January 5, 2026

**RE: *Albuquerque School of Excellence
5200 & 5310 Sequoia Rd NW
Erosion and Sediment Control Plan: G11E048/ SWQ-2025-00041***

COMMENT RESPONSE LETTER

EROSION CONTROL PLAN

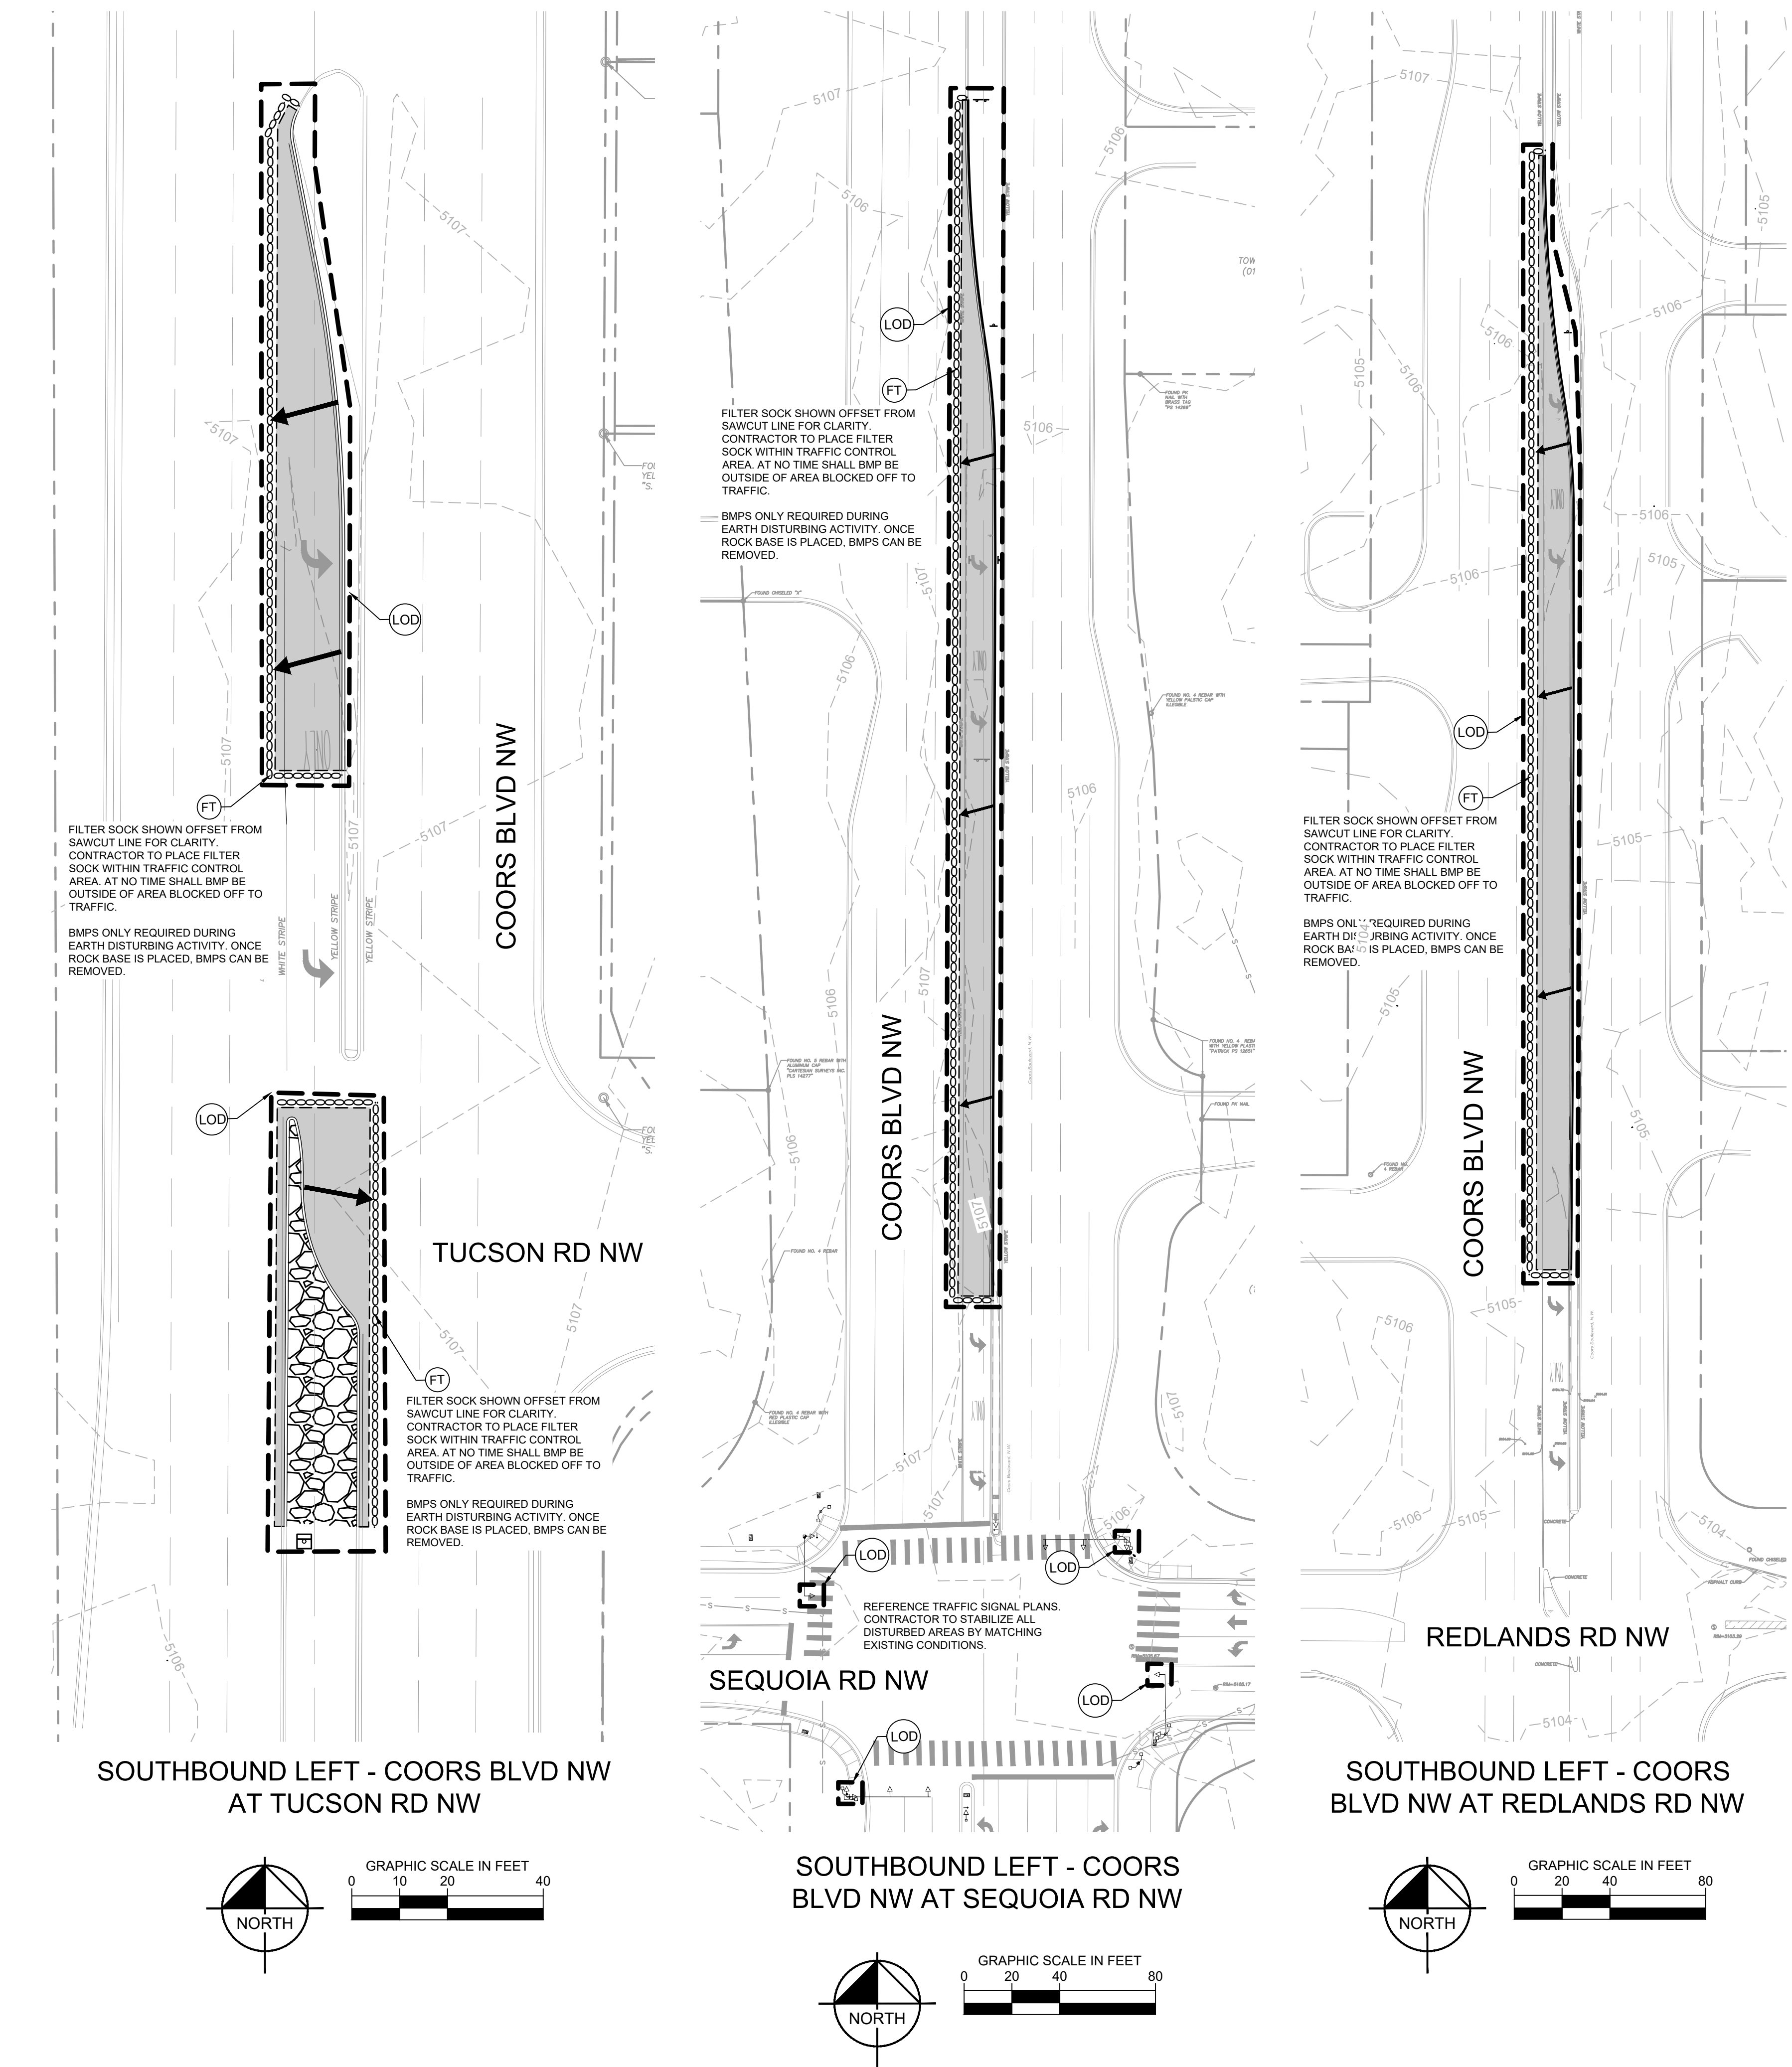
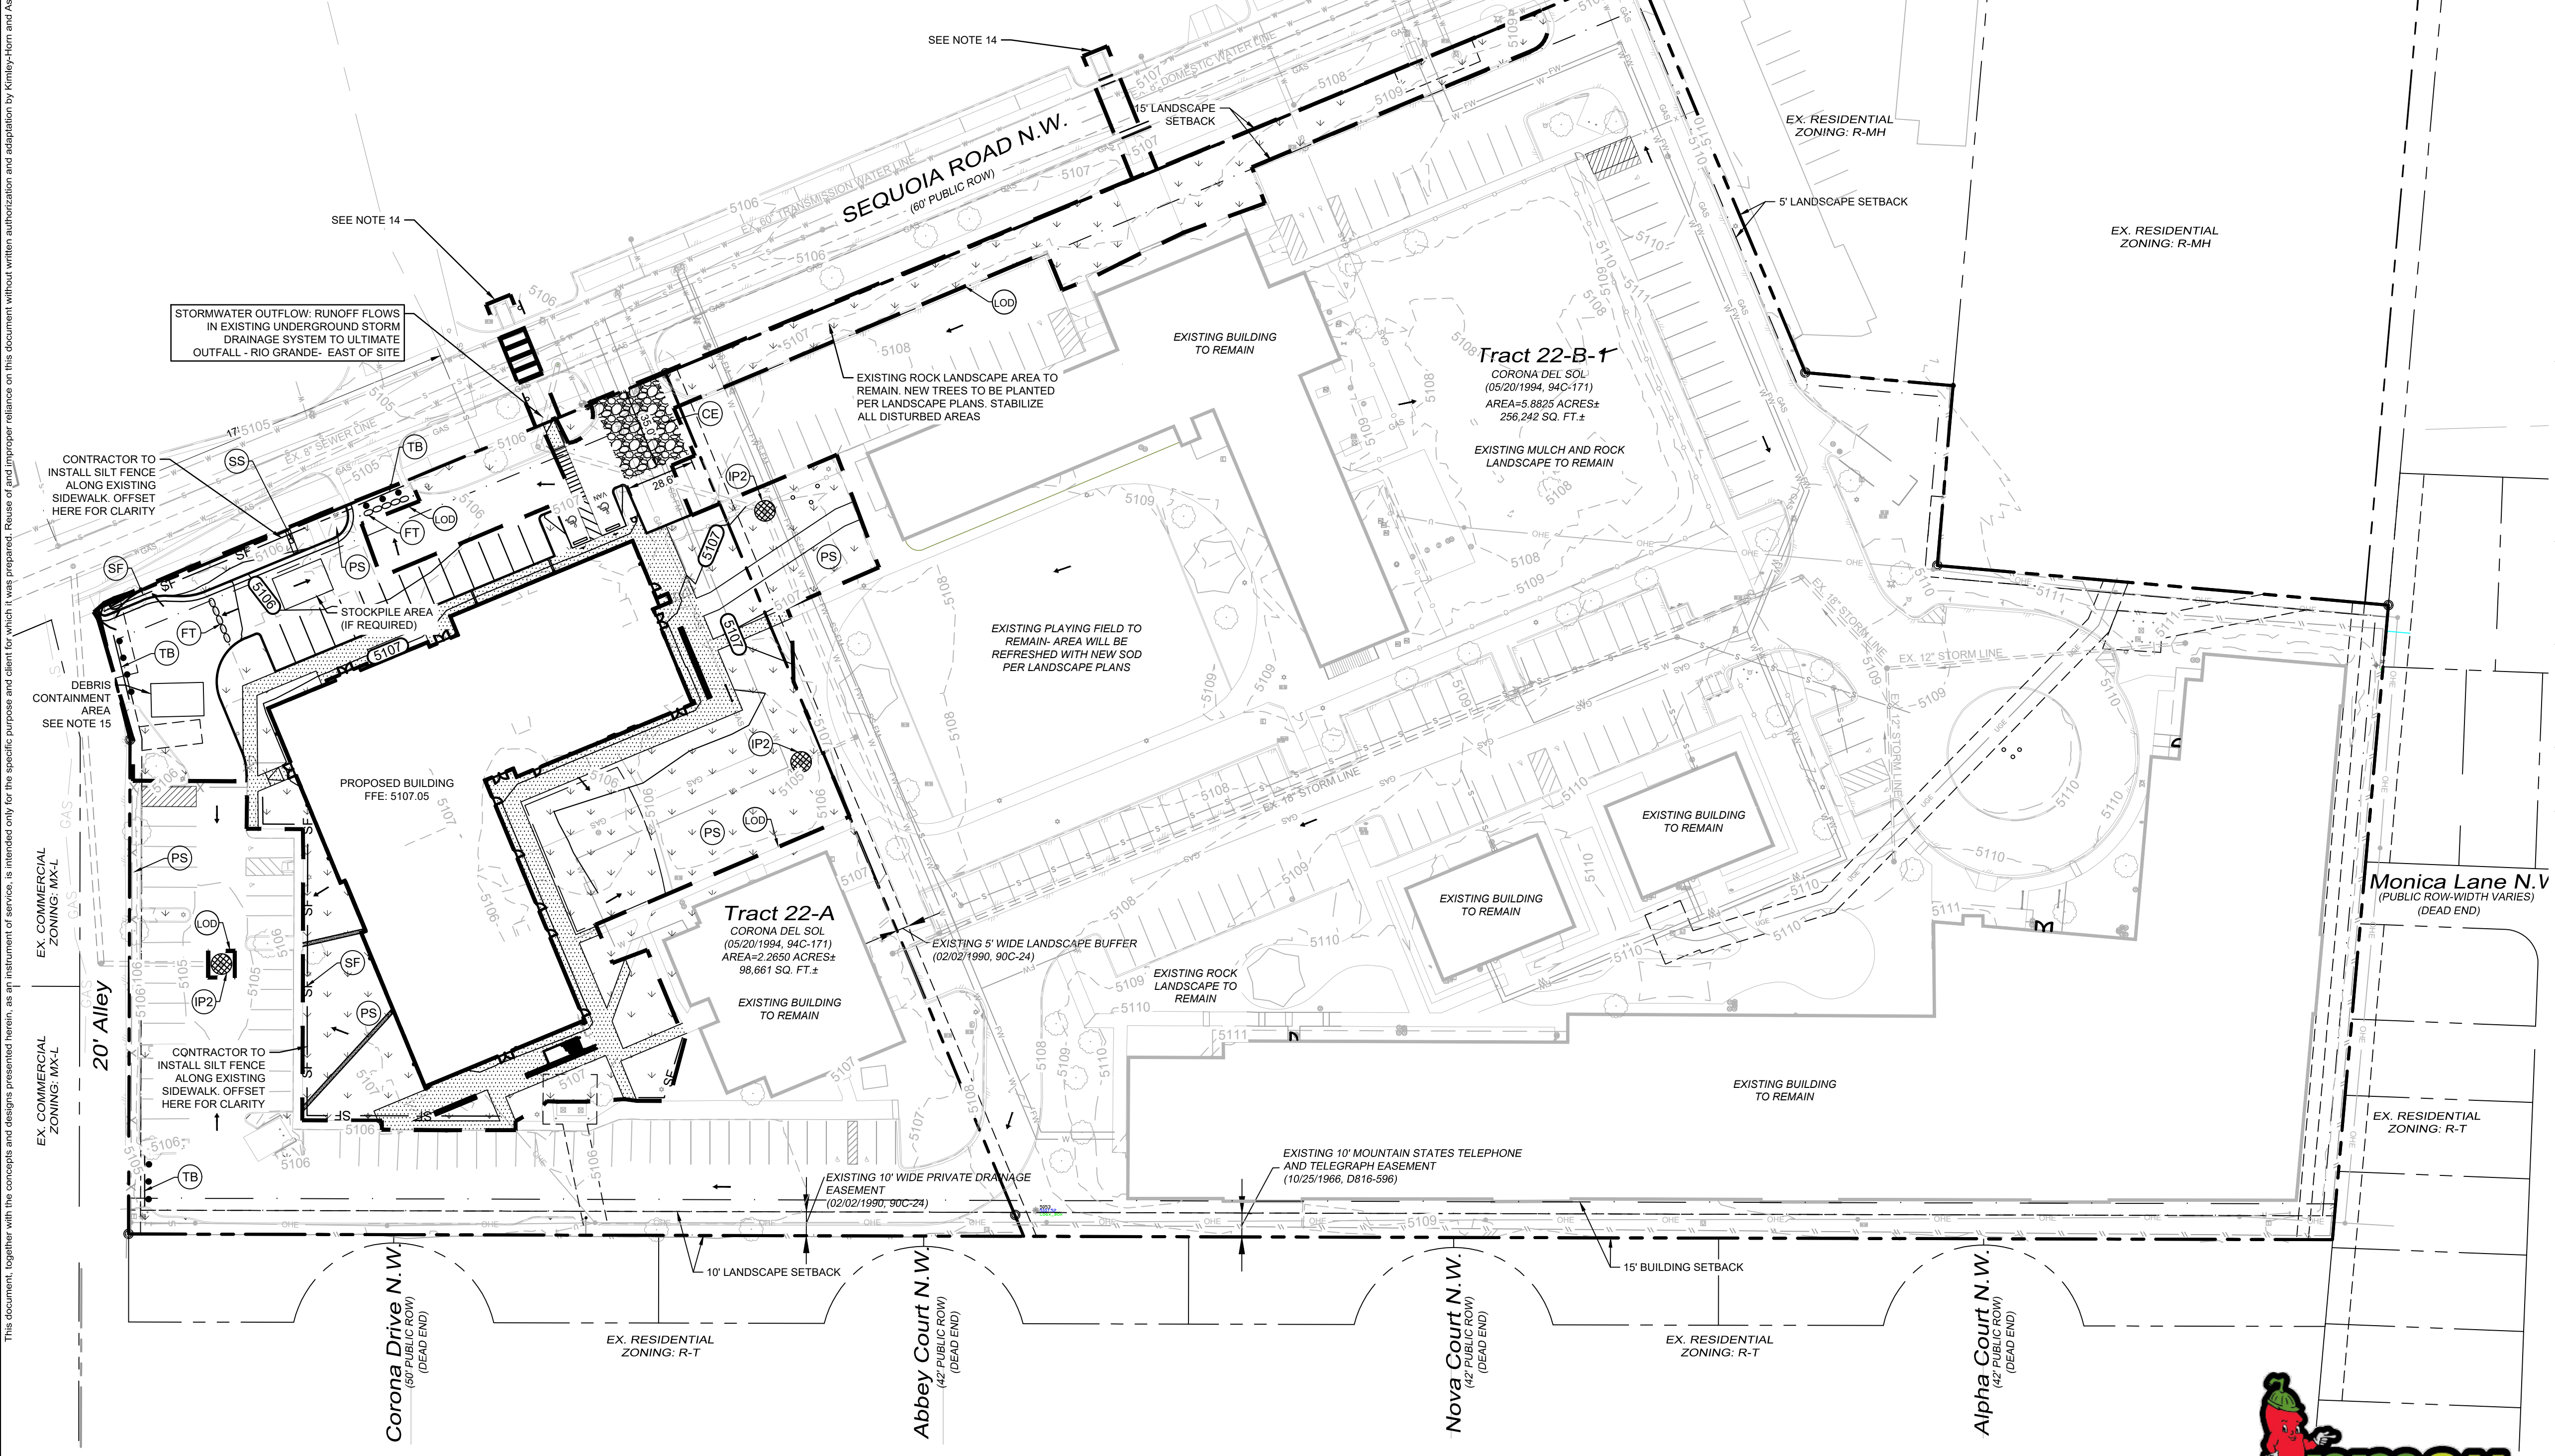
Response: Current property owner information and engineer are listed in ABQ-PLAN.
2. This project's scope includes demolition of a building larger than 10,000 sf. built before 1980. You must correct the NOI and identify controls on the ESC Plan to minimize the exposure of PCB-containing building materials to precipitation and stormwater. Specify covers for all waste, including PCB-containing demolition debris, during precipitation and non-work hours per CGP 2.3.3.e.

Response: This requirement has been added as note 15 to the ESC notes and noted next to the debris containment area on the ESC plan.
3. Note #11 of the Additional Site-Specific Notes says "there are no waters of the us on the site or within a mile of the site," when they are less than a half mile from the site. The note must be corrected and identify if any of these receiving waters are listed as impaired, per CGP 7.2.4. The ESC Plan must also show the Locations of all receiving waters within one mile downstream of the site's discharge point(s).
